From: Ian Stocks [REDACTED] **On Behalf Of** FRS Water and Access
Sent: 22 June 2022 12:35
To: Planning.Responses <Planning.Responses@arun.gov.uk>
Subject: Hydrant condition - Y/60/22/PL Longacre Maypole Lane Yapton BN18 ODR

HYDRANT CONDITION CONSULTATION WITH PLANNING AUTHORITY

Planning Ref: Y/60/22/PL

Description: Erection of 1 No detached dwelling and garage with shared access from Maypole Lane. This application is a Departure from the Development Plan and this site is in CIL Zone 3 and is CIL Liable as a new dwelling.

Figure 7: Vehicle Access and Tracking

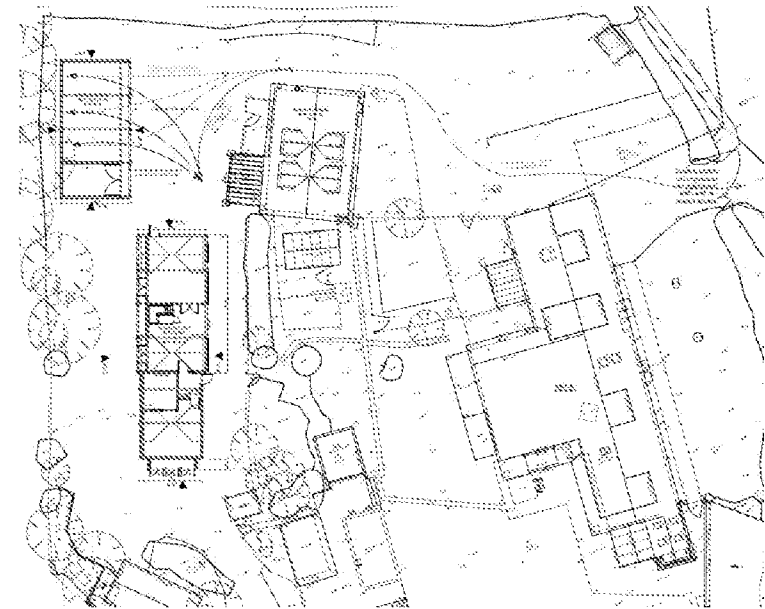
Evidence will also be required that Fire Service vehicle access meets with the requirements identified in Approved Document B Volume 1 2019 Edition: B5 Section 13, including Table 13.1 and diagram 13.1.
